KITTITAS COUNTY COMMUNITY DEVELOPMENT SERVICES

December 29, 2020

Subject: Forest Ridge Phase 1 (LPF-20-00005) Final Long Plat – Return of Application and Request for Additional Information

OPEN SPACE COMPLIANCE MAP

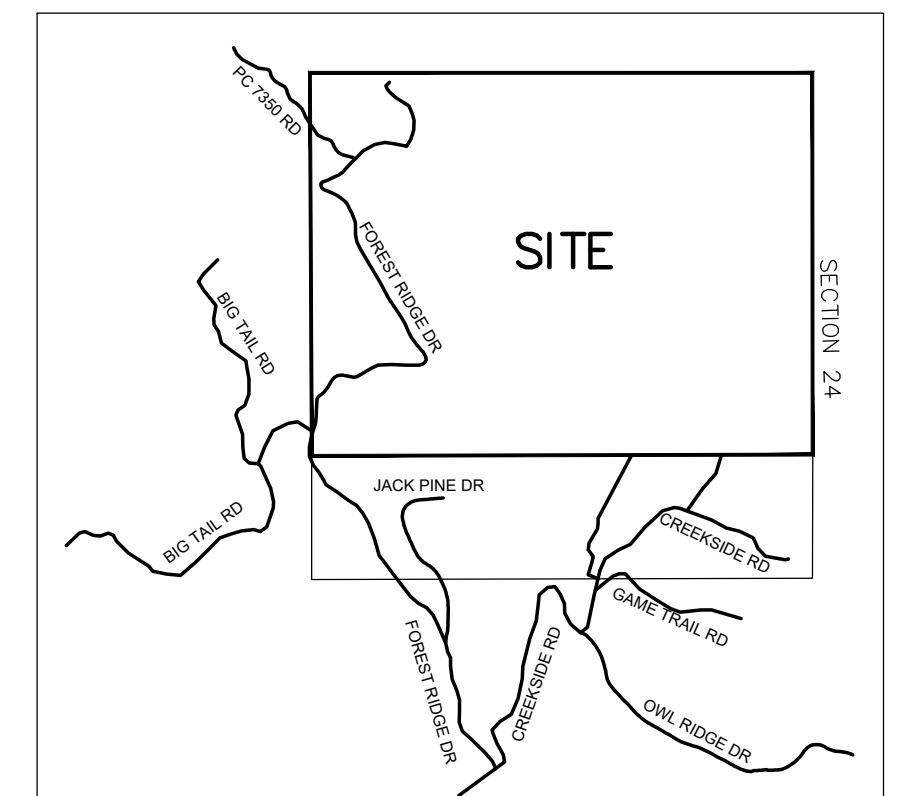
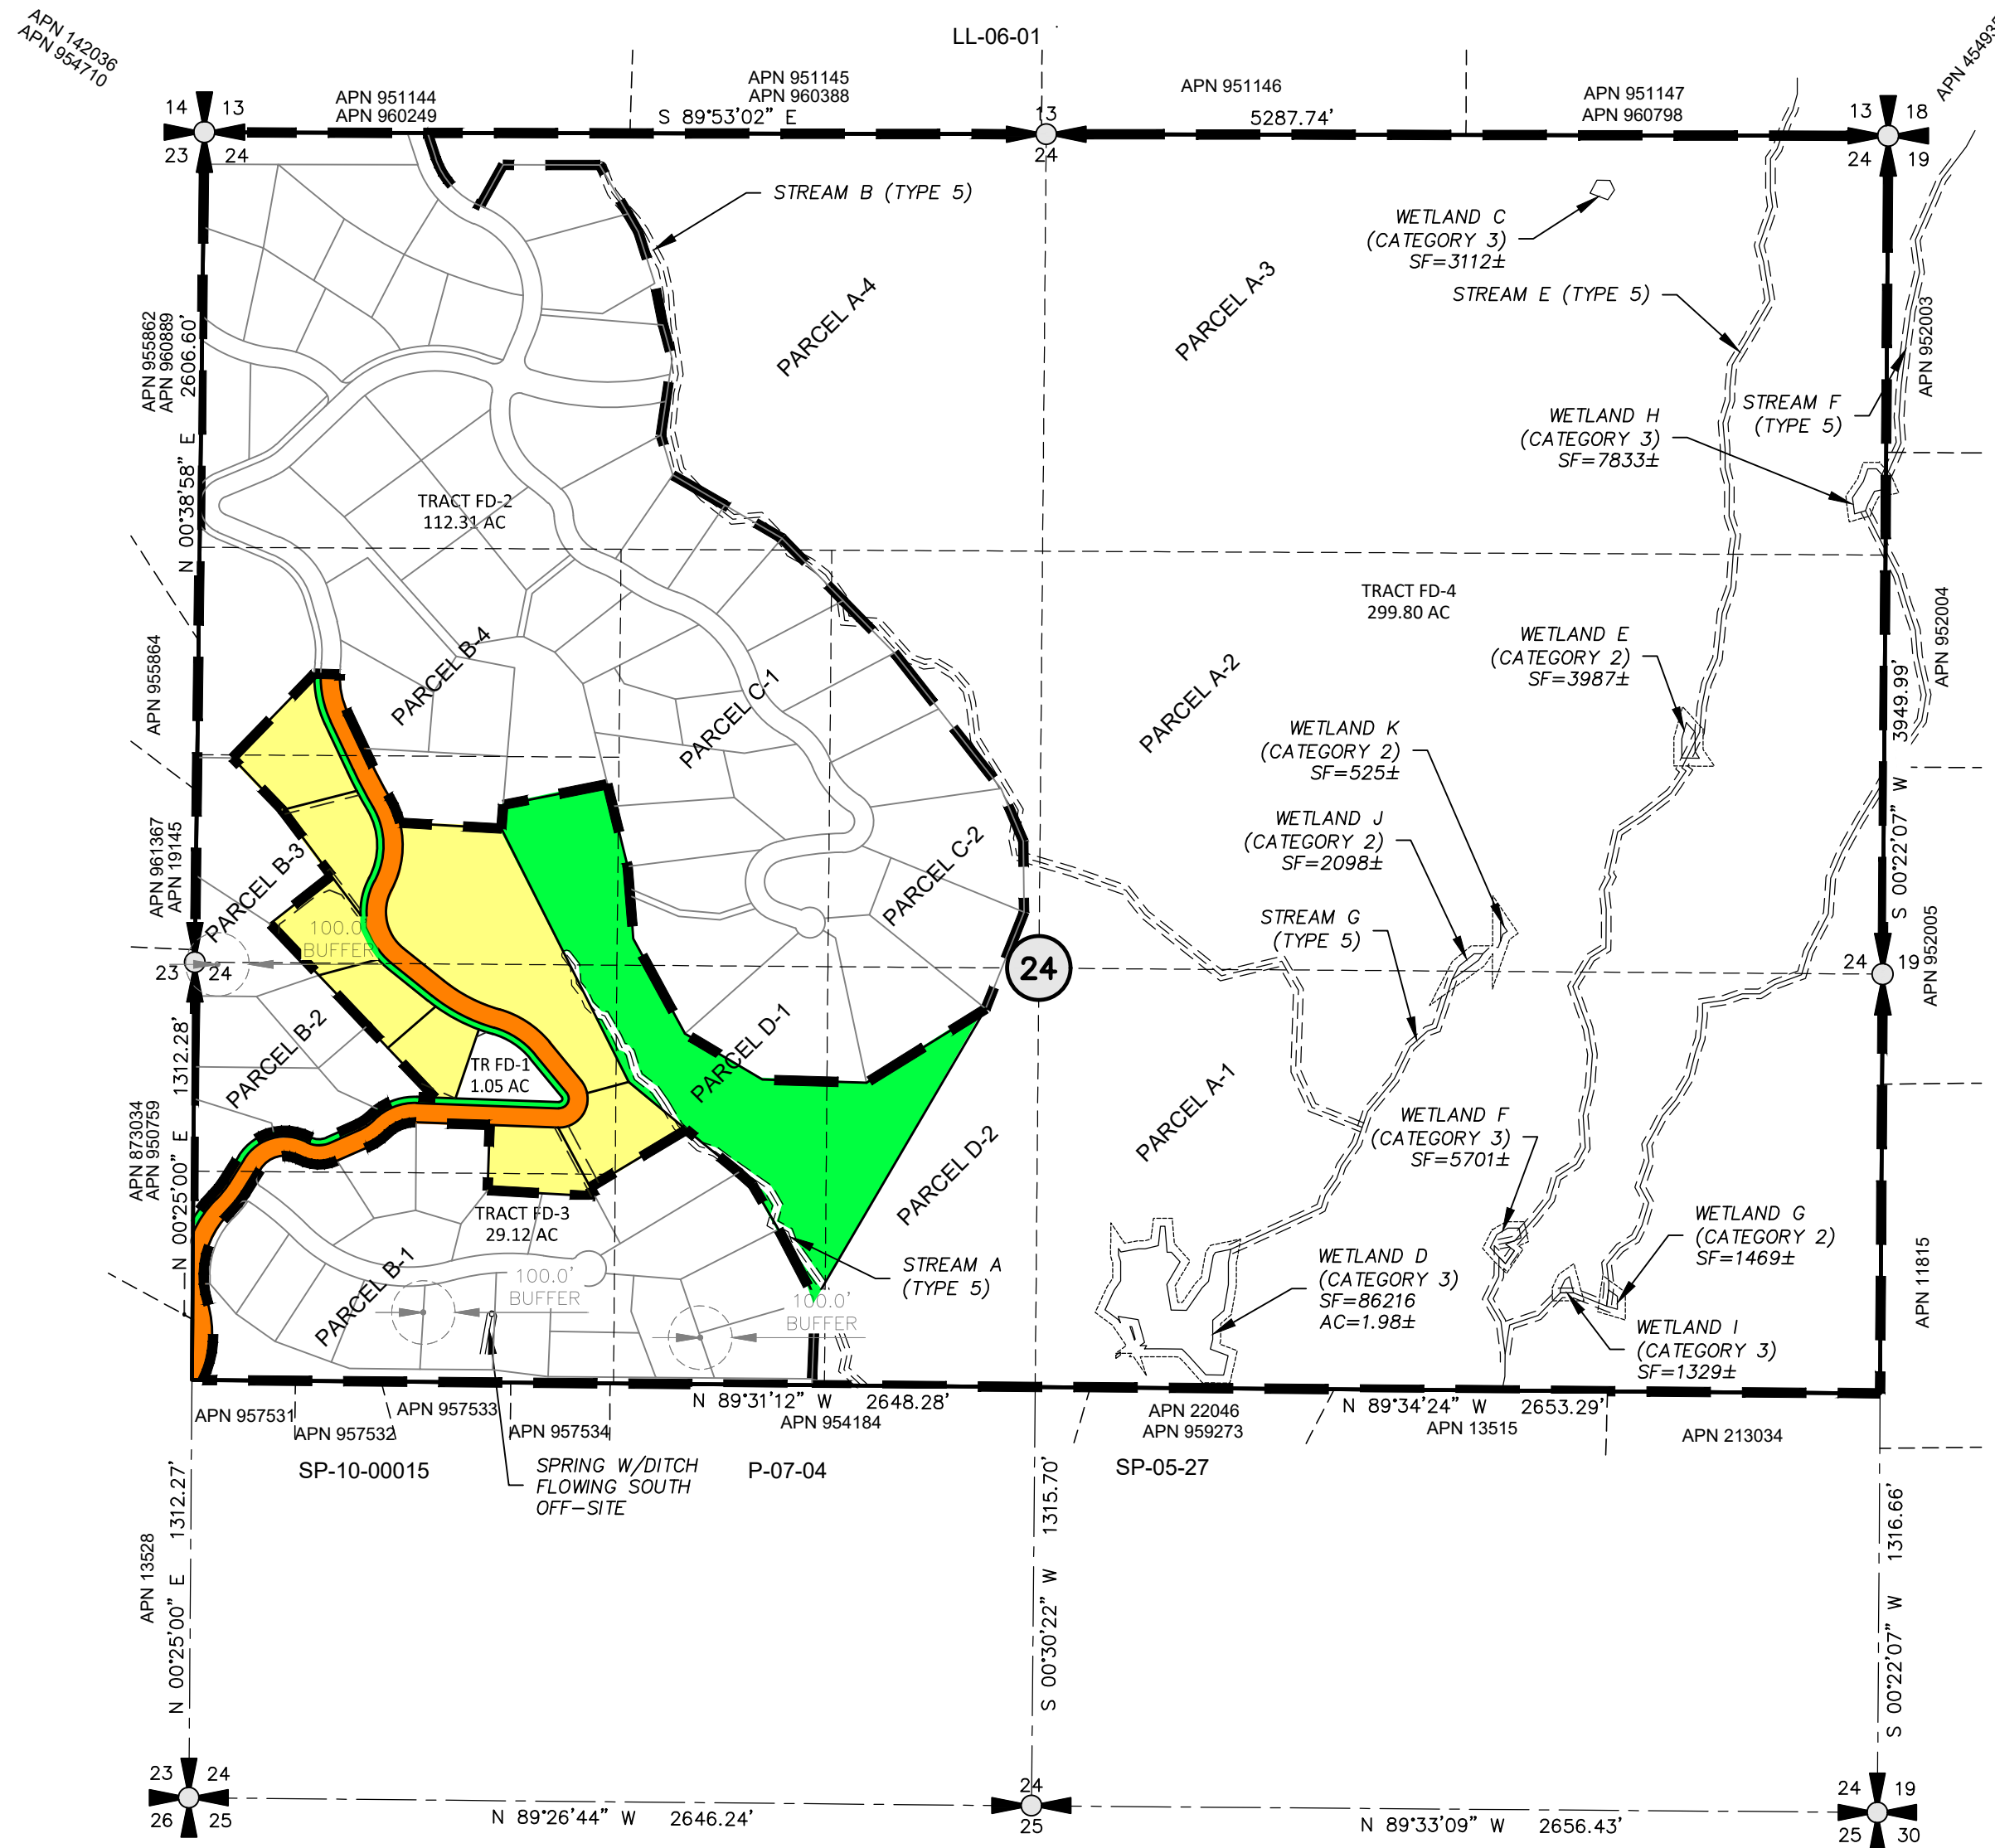
- Final mylars shall include the final plat number LPF-20-00005.
- Resolution 2010-137 Condition 8 states, “Prior to final plat approval, the applicant shall present to the County for review and approval a map demonstrating that at least 40% of the total plat area meets the open space requirements of Chapter 16.09.” The condition compliance document provided notes that this map is included in the submittal materials, but staff could not locate this.
